WEST SUSSEX COUNTY COUNCIL CONSULTATION

TO:	Arun District Council FAO:Simon Davies
FROM:	WSCC - Highways Authority
DATE:	8 April 2020
LOCATION:	Land at Summer Lane Pagham PO21 4NG
SUBJECT:	P/23/20/DOC Approval of details reserved by condition imposed under ref P/58/15/OUT relating to Condition Nos 8 - ecological, 16 - Construction Management Plan, 17 - archaeological, 21 - Public Open Space, 22 - broadband strategy and 23 renewable and low carbon energy
DATE OF SITE VISIT:	n/a
RECOMMENDATION:	Advice
S106 CONTRIBUTION TOTAL:	n/a

Traffic Route Plan

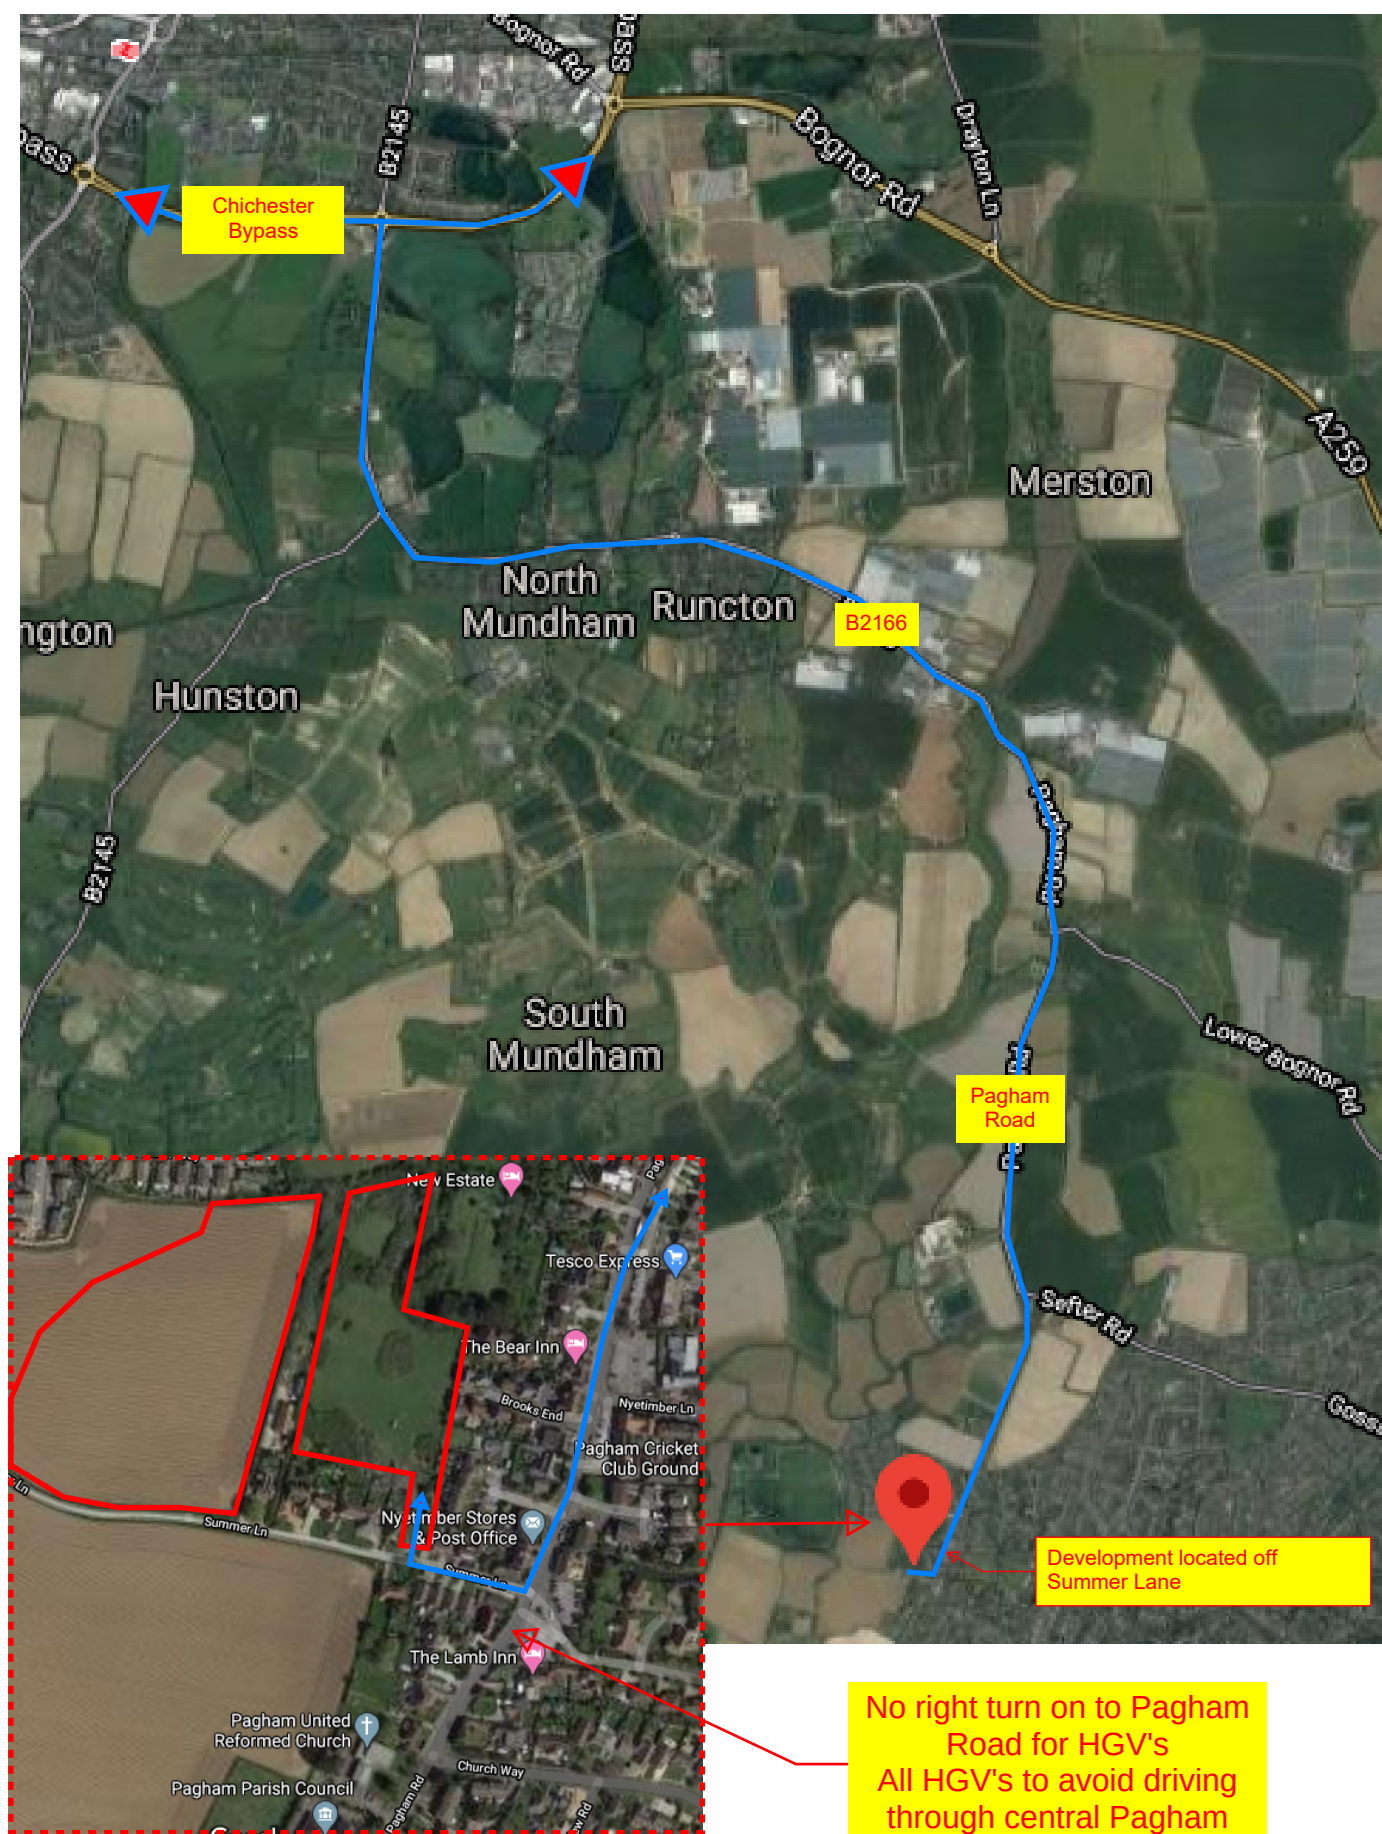
Regarding vehicle routing on the wider network, the CMP should indicate those routes likely to be used by HGVs as well as those routes that are to be avoided.

Appendix C – Site Set Up Plan

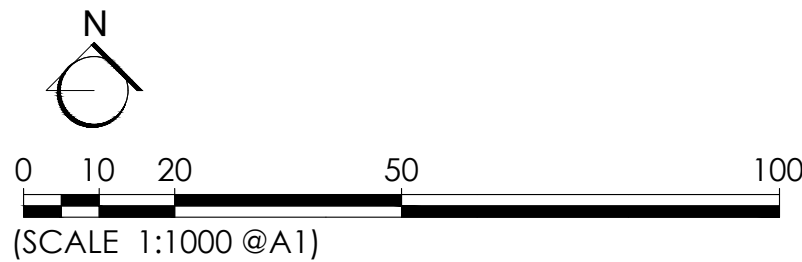
A site setup plan is included, this shows only storage and welfare areas. No details are included of contractor car parking or where this is to be located. Related to this, it should be demonstrated that the car parking is adequate to meet likely peak contractor parking demands.

Details should also be included of the location of wheel washing.
